Response to planning refusal and support for subsequent design changes and variation application

Document directed around refusal letter for convenient reference and context. - 20/02/2024 V2.0

Prev Application: 23/01224/FULHH Town / Parish: Brightlingsea Town Council

Address: 70 Ladysmith Avenue Brightlingsea Colchester

type proposed street context 1

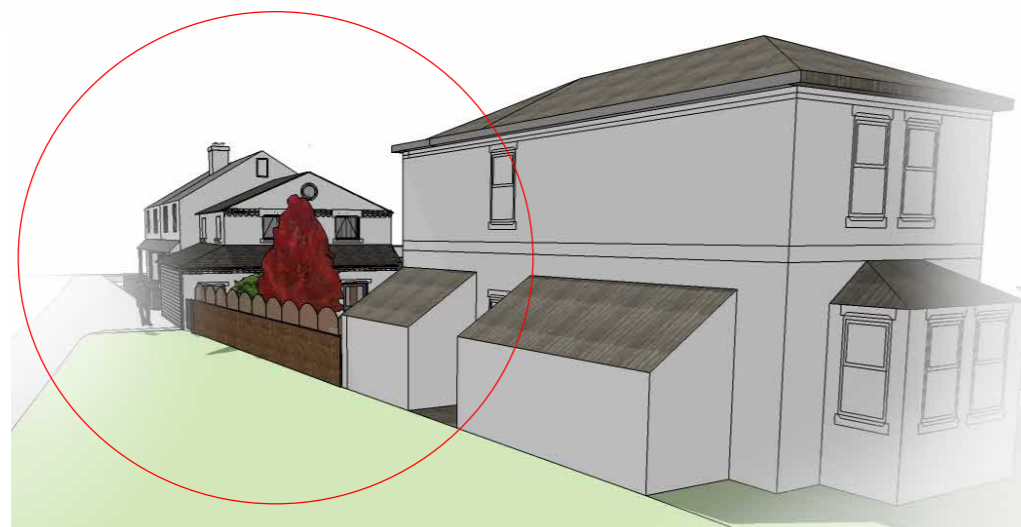
The proposal will result in the loss of this single storey garage and replacement with two storey outbuilding which would be positioned along the site's boundary shared with Spring Road. This siting would result in the new building appearing as a prominent addition within Spring Road and its two-storey nature would occupy the open space between the application house and its neighbour resulting in a loss of a significant characteristic here.

The existing single storey garage also contributes to this traditional appearance by being single storey and very much subservient in appearance to the host dwelling. The design of the new building is modern in comparison which would not relate well to the traditional appearance set by other houses within Spring Road.

See above comments relating to street scene precedents and changes in design proposed, also 'orange text'. Defining the new proposal as more subservient to host dwelling at No 70 in its reduced mass/volume. Now a balanced stepping down occurs at the end of the cottages of Spring Road.

In our new proposal with lower ridge height offers a stepping down at the end of the street mass into the clear open space between the proposal and the host dwelling. It should be considered that blending this mass into the open space is a more appropriate way to deal with perceptions of mass and guidance under Local plan and NPPF. The ridge of proposed now lower than the host building and more in balance with the bungalows across from Spring Road which stand above the proposal on their natural terraced locations.

dwg no 0/A200/PR/001 rev A

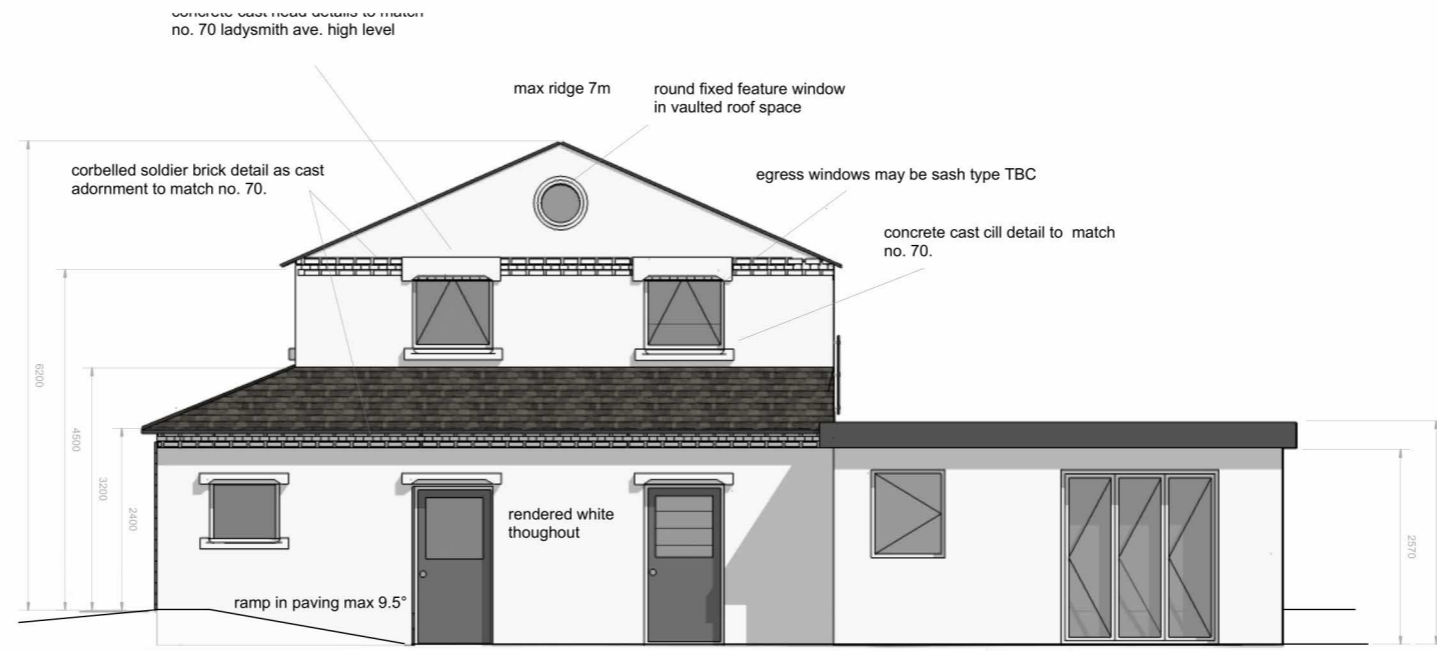
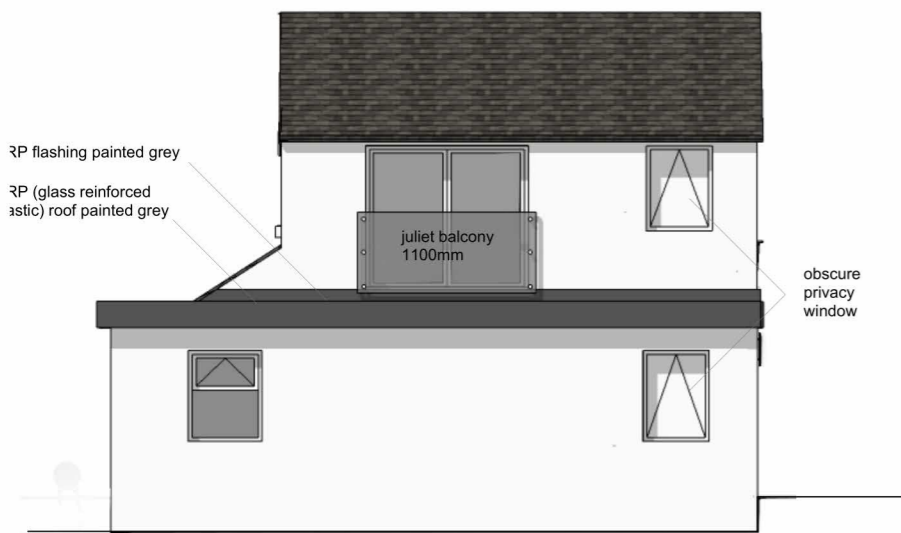
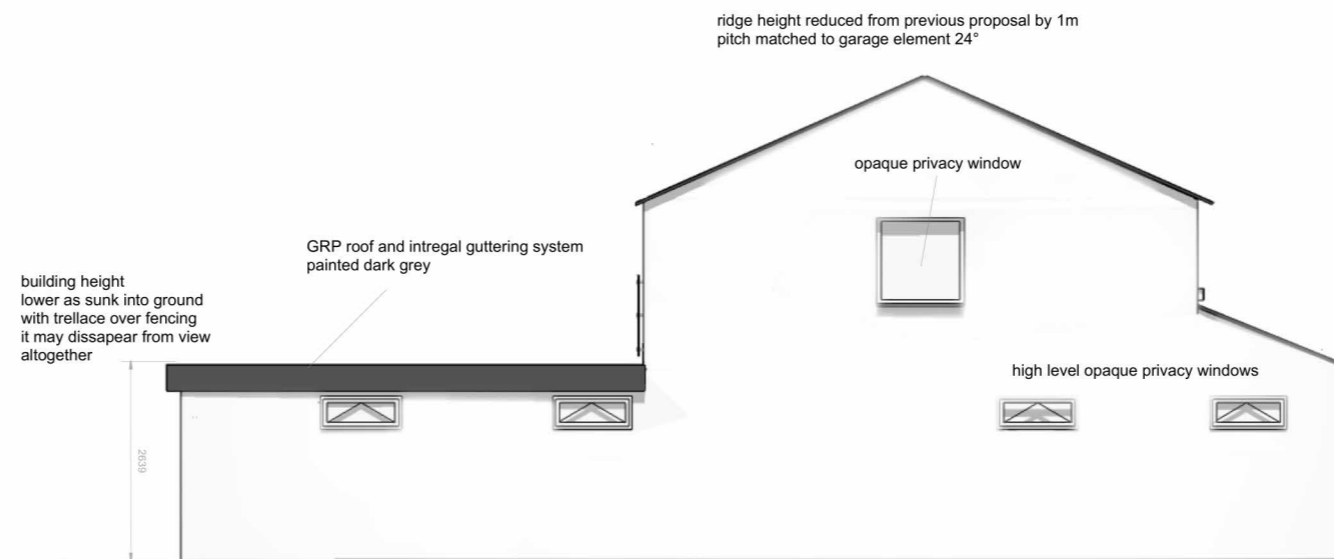
1. Reduction of two storey element, ridge height by over 1m, with a reduction in roof pitch to 24°, matching the mono-pitch of the set-back roof of the garage at the Spring Road frontage. This reduces the roof mass/volume by 30% or more.
2. Removal from the design, of access and use of roof terrace. Removal of privacy screens, mono-pitch and parapet wall elements. Removal of second stairs (even though contrary to building control general requirements for fire escape). Instead replacing the first floor workspace with a inward opening French door or sliding door system and Juliet balcony, whose height is within building regulation of 1100mm.
3. Vertically recessing the rear single storey element of the annex and some of the 2 storey element downwards into the landscape by 440mm.

Building Element	Old Height	Newly Proposed Height	Reduction
Ridge Height – 2 Storey Element	7280	6200	1080
Eaves Height – 2 Storey Element	4650	4500	150
Eaves Height Garage Roof Element	2617	2400	217
Annex Ridge	2870	2496	374
Annex Eaves	2643	2570	73

The use of white render would exacerbate the appearance of the new building increasing its prominence and impact onto the streetscene. The use of glazed balustrade and vertical cladding would also have a further detrimental impact to the locale it would appear striking and out of character to this largely traditional streetscene. It is therefore considered that the new building due to its size, design and siting on the side boundary would result in a prominent addition to the site which would appear as an incongruous addition to the existing site and its surroundings thereby having a detrimental impact to the character and appearance of the area. This impact would have further adverse effects due to the significant reduction in open space, at first floor level, as you enter Spring Road.

proposed plan | land at rear of 70 ladysmith avenue, brightlingsea

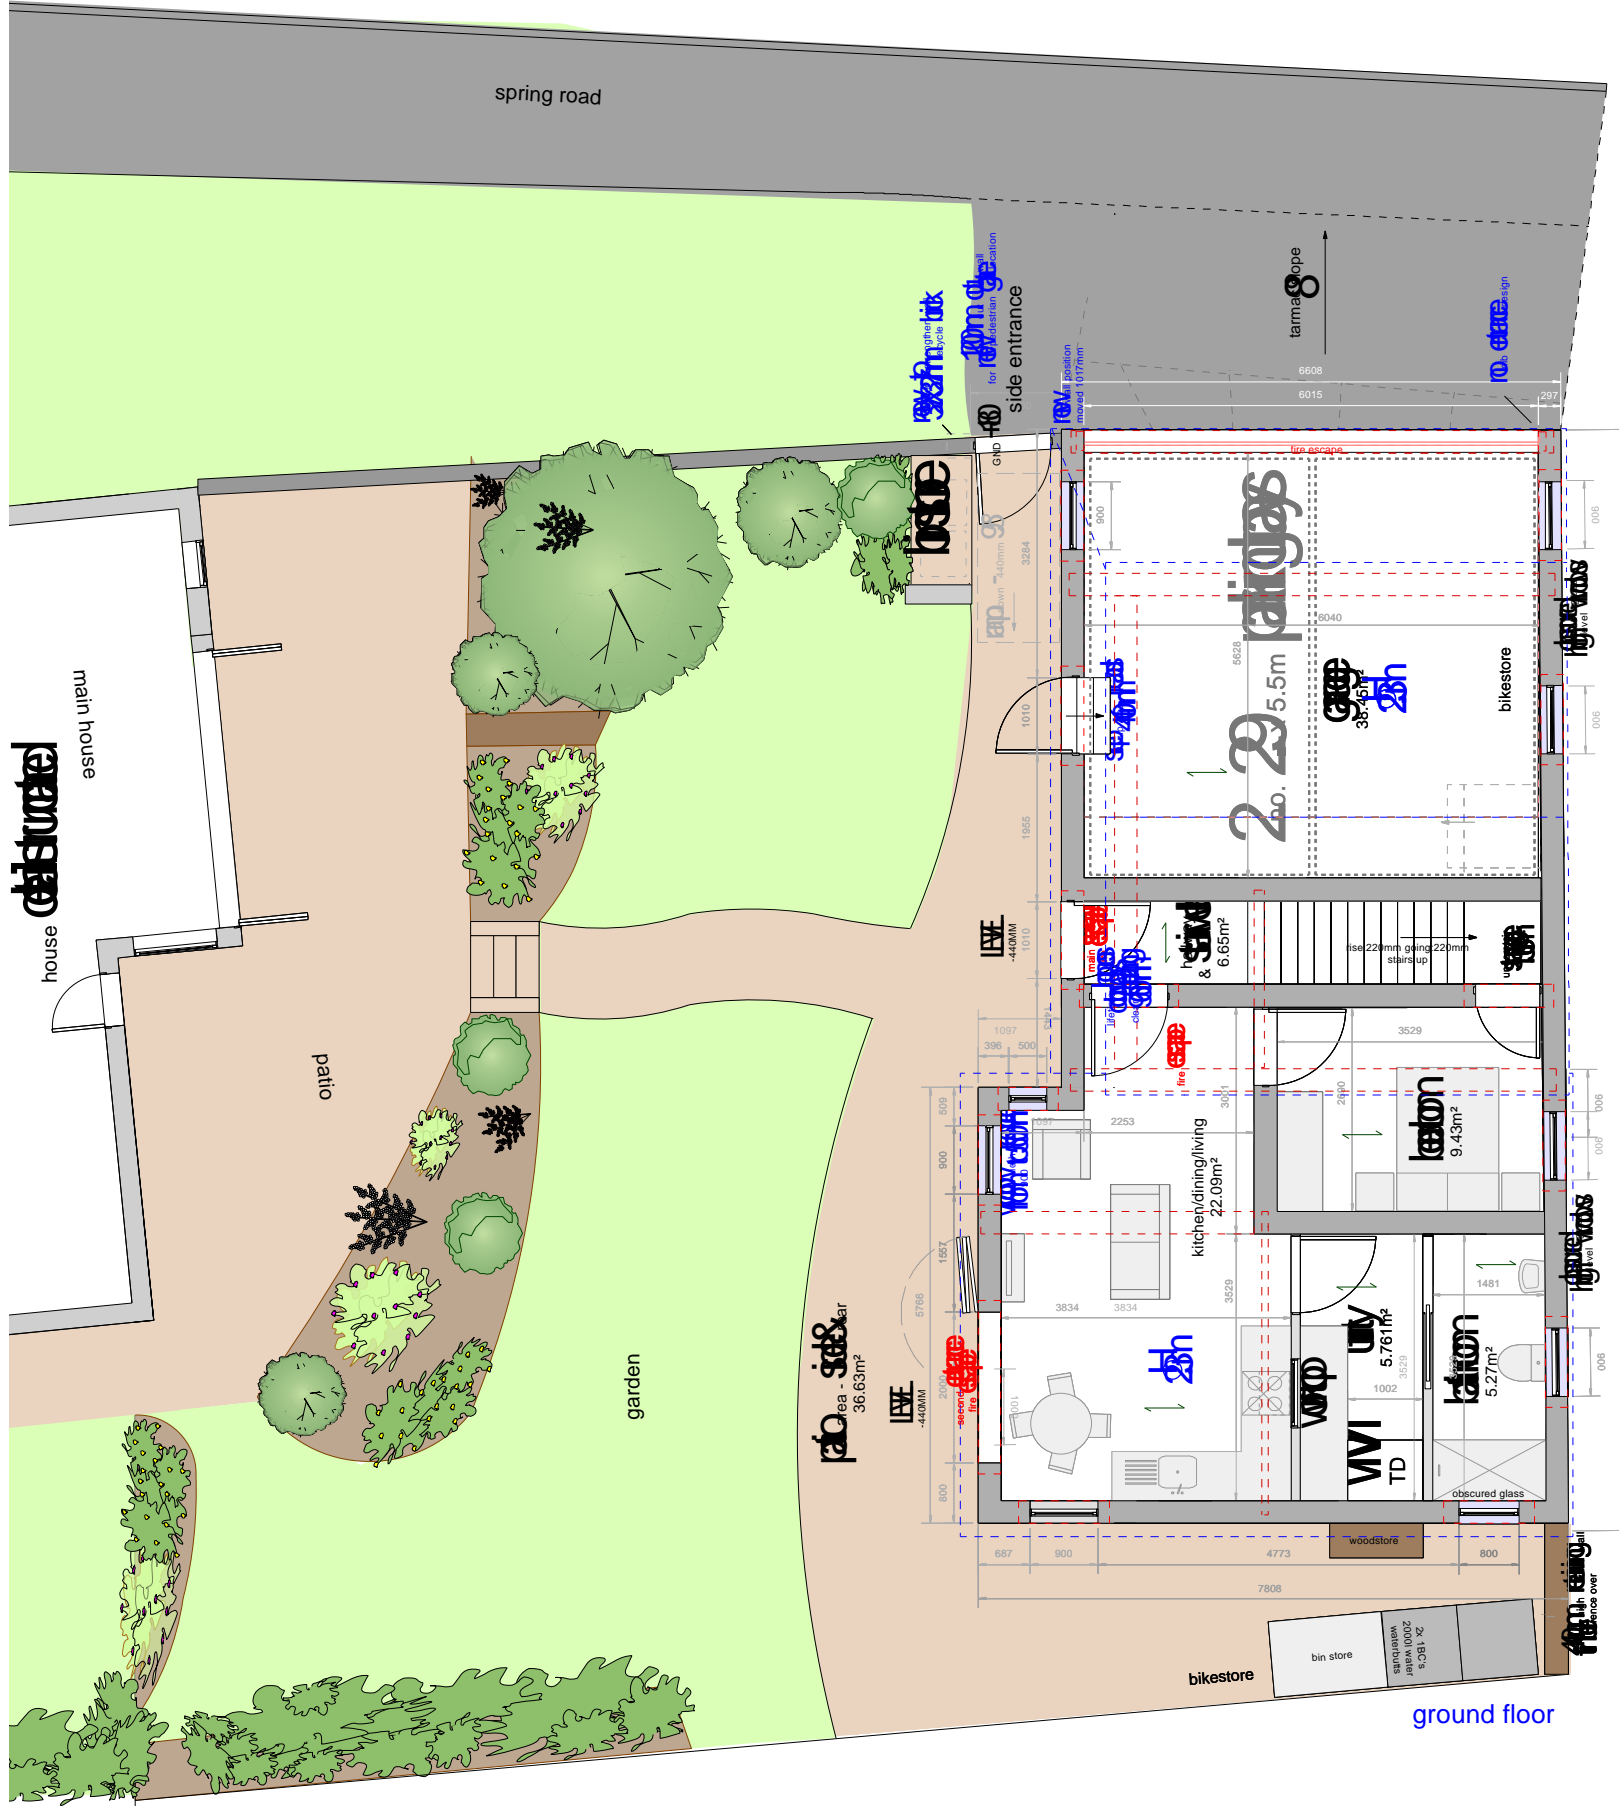
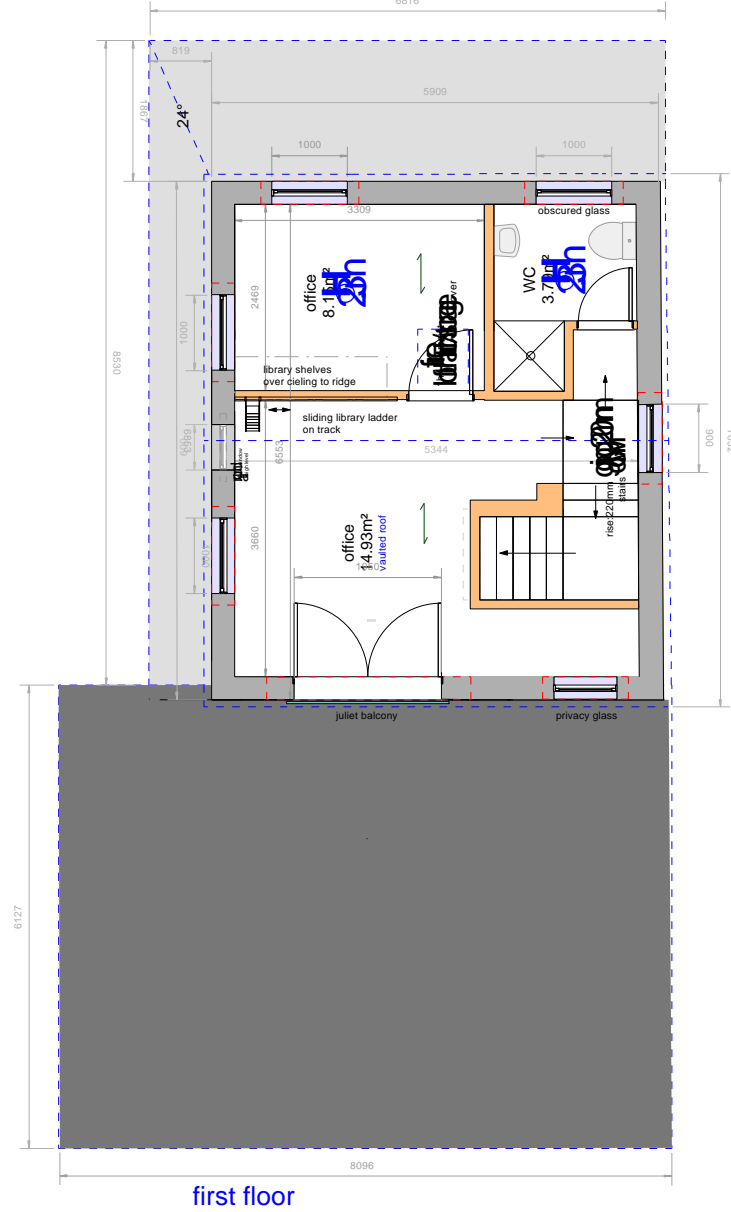
The ECC Parking Standards states that where a house comprises of two or more bedrooms that 2no parking spaces should be retained which measure 5.5m by 2.9m per space. They also request that new garages should have an internal measurement of 7m by 3m. The proposed garage will measure 5.8 by 4.9m internally therefore conflicting with the above standards. Whilst there is some green space located around the front and side of the house this has not been identified as off-street parking on the information provided and due to the position of the existing vehicular access would not be suitable for safe access or the manoeuvring of vehicles. It is also noted that some of the green verge around the house has not been included within the red line of the site plan and would therefore not appear part of this site's residential curtilage.

The existing garage at present is of a size which is under the above requirements and therefore does not provide sufficient parking in line with these standards. The proposed garage will also be under these standards and therefore does meet the parking needs of the house and the additional accommodation proposed. The proposal therefore does not demonstrate sufficient parking measures in line with the above policies or standards.

We propose 2 no. parking bays at 5.5 by 2.9m as required under ECC parking standards, and commented by Essex Highways Consultation. We are also prepared to evidence by means of parking survey that outside 8m of the visibility splay termination and junction from Spring Road to Ladysmith Ave there is 4 no. street parking spaces on the East and West sides of Ladysmith Ave directly adjacent to the host dwelling no 70. This brings the parking facility up to a potential of two primary parking bays in the garage and 4 dynamic street parking spaces, unaffacting parking congestion on Spring Road or Ladysmith Ave.
